## NORFOLK BOREAS OFFSHORE WINDFARM DEADLINE 2 SUBMISSION

### CAWSTON PARISH COUNCIL'S RESPONSE TO THE EXAMINING AUTHORITY'S WRITTEN QUESTIONS AND REQUESTS FOR INFORMATION – EXQ1

##### **The Highway Intervention Scheme**

13 APPENDIX 6 SCHEME OF HIGHWAY MITIGATION (B1145, CAWSTON)

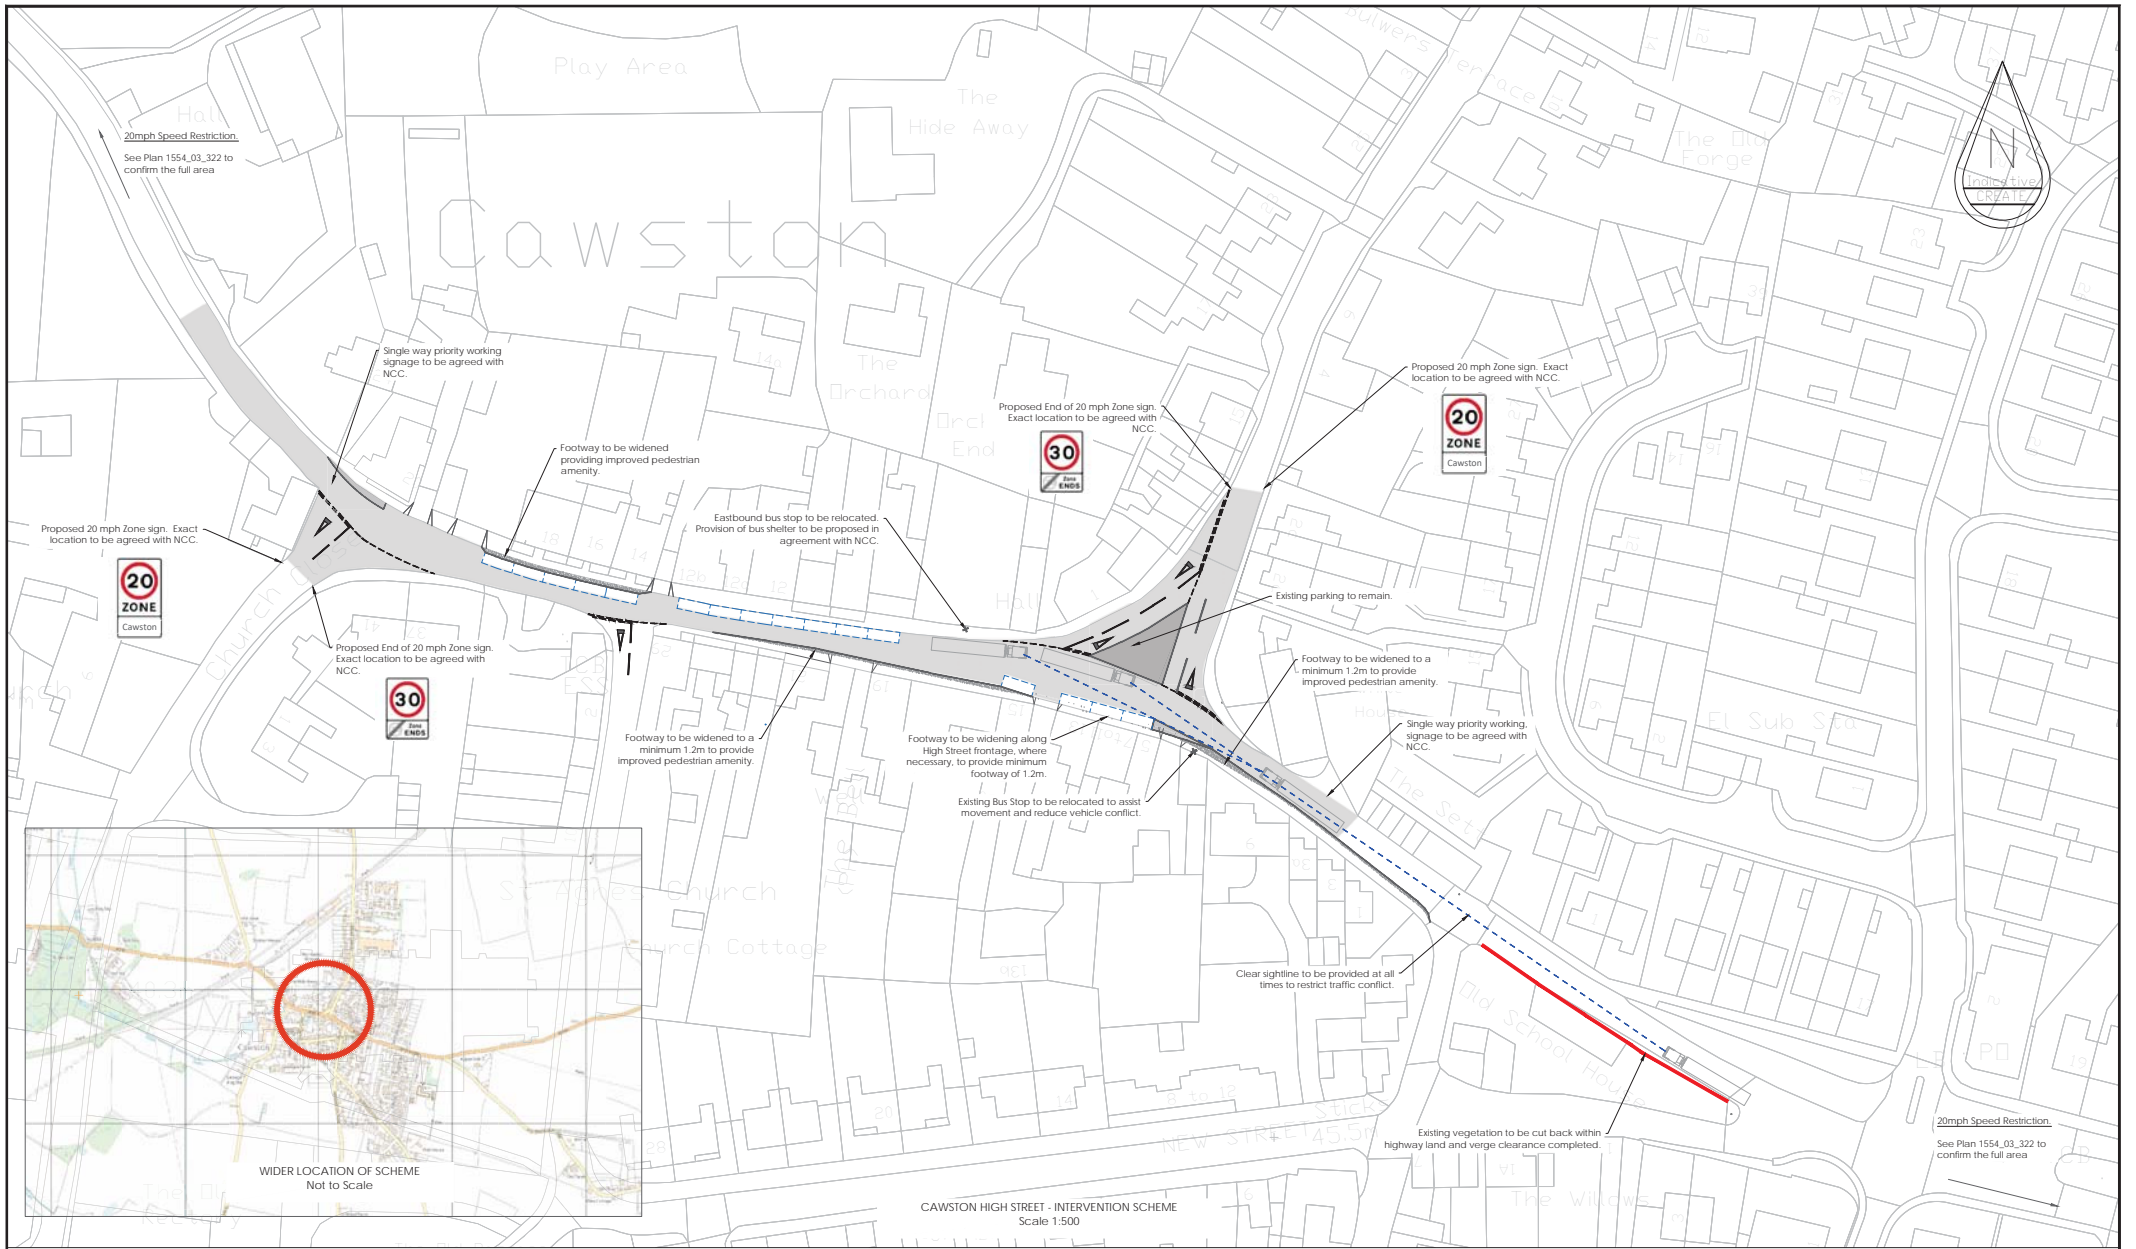
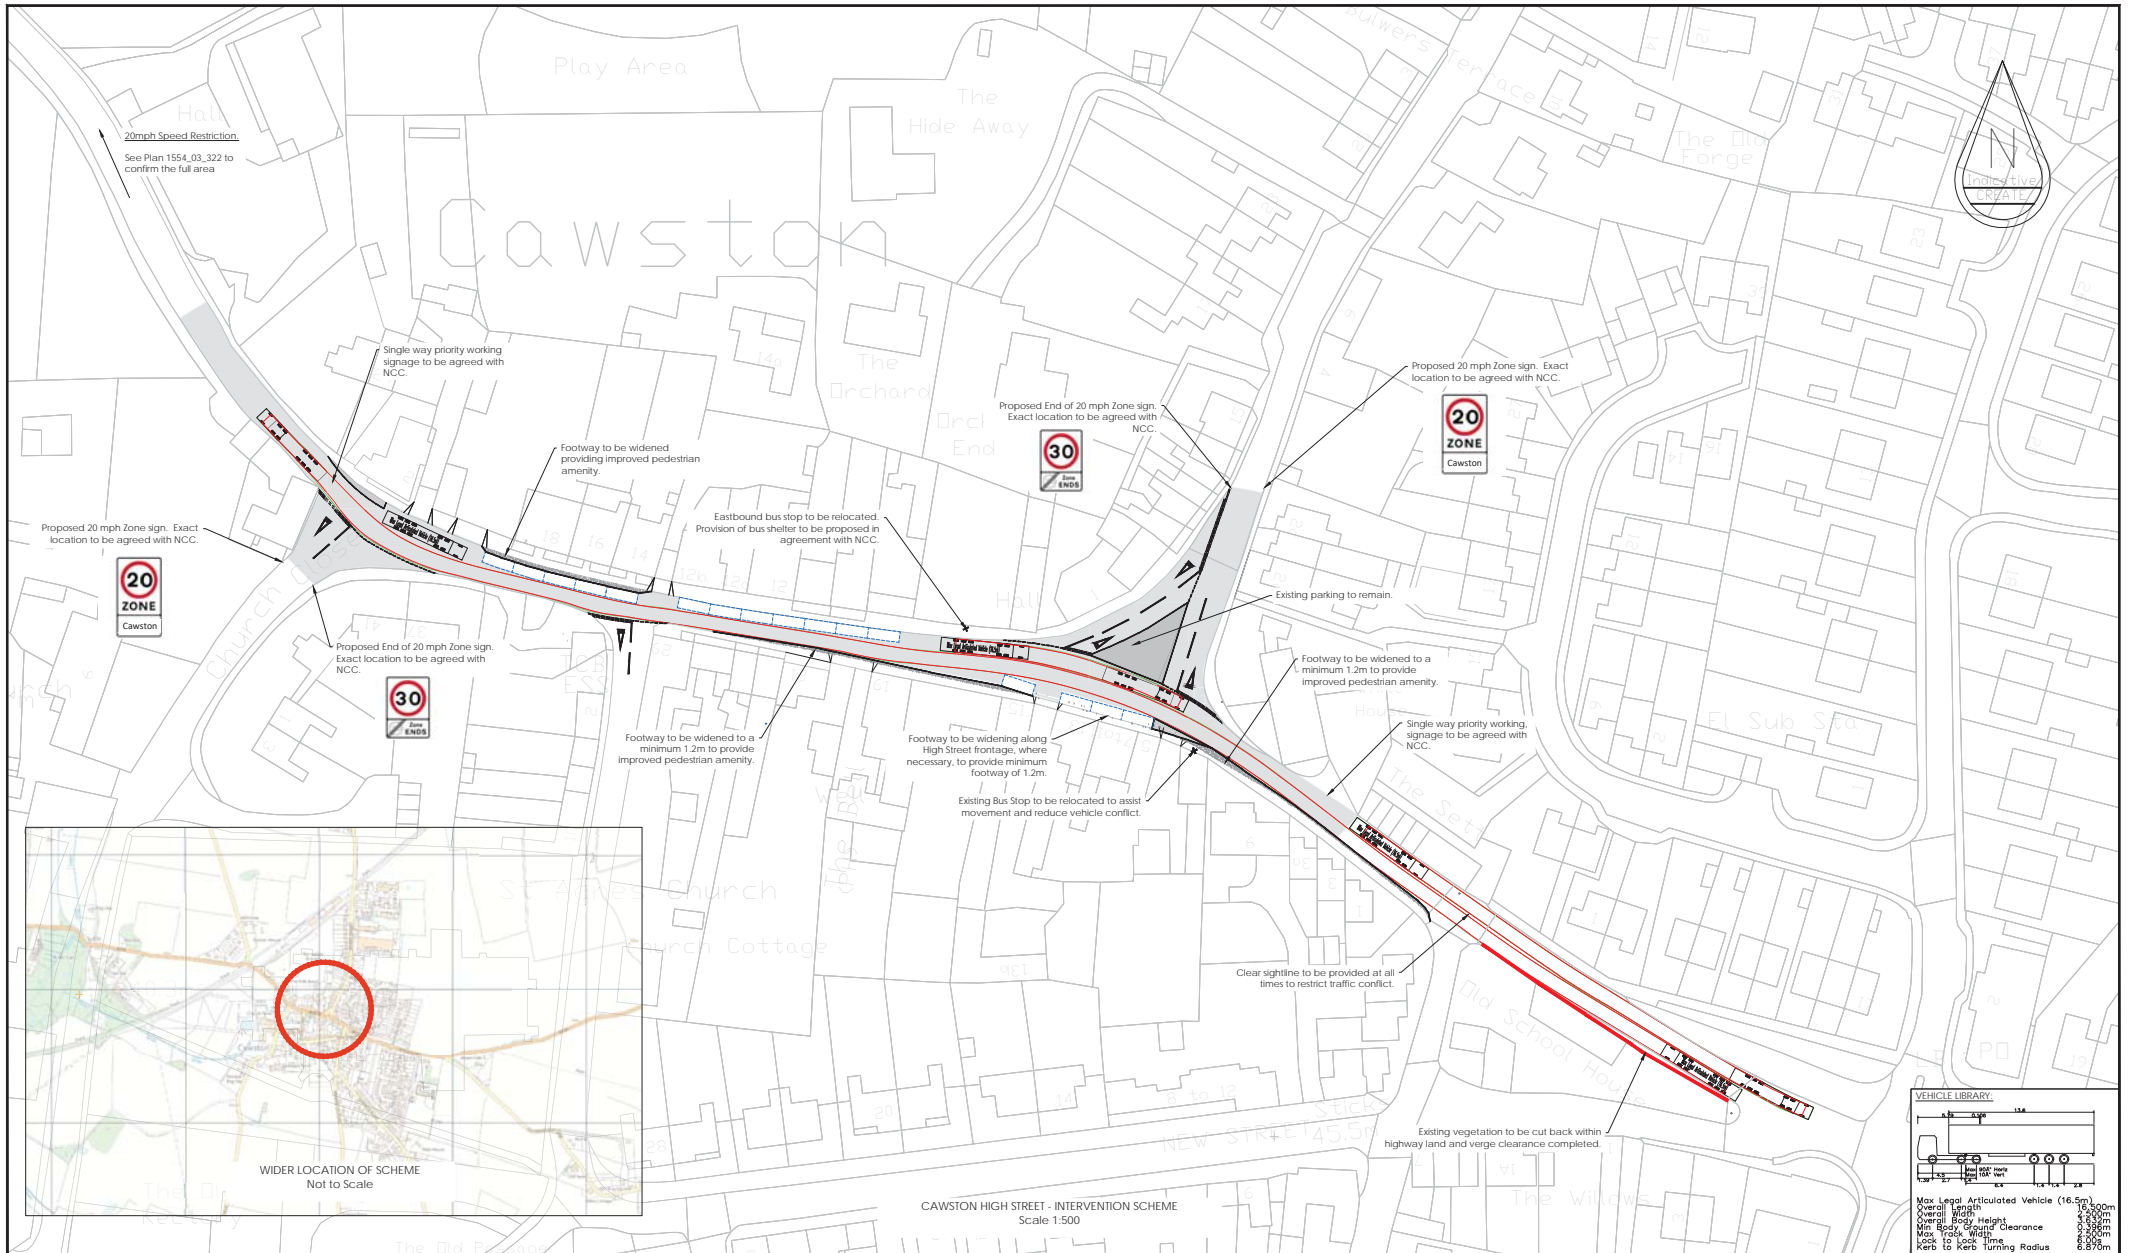
Pedestrians' safety in Cawston was said to be a priority for the first version of the Highway Intervention Scheme and footpath widening was the key feature of the scheme proposed to mitigate the impact on pedestrians.

Now, in what we believe is its sixth version of the scheme, the applicant has decided they require every inch of road, and footpath, to enable their HGV and other construction traffic to manoeuvre past each other in the village centre. To accomplish this feat the proposed footway widening, previously said to be crucial to guaranteeing pedestrian safety, has been completely removed.

1. how pedestrians in Cawston village might safely cross the B1145 to use local services and facilities with the large volumes of construction traffic travelling in both easterly and westerly directions.

2. the safety of pedestrians using the narrow footways on the B1145 in Cawston village when HGV movements are taking place.
3. the total numbers of construction traffic and its phasing. Whilst HGV traffic is planned to avoid Link 34 at sensitive times, the large volumes of non-HGV construction traffic will still be trying to negotiate the village centre when it is at its busiest under current road conditions.
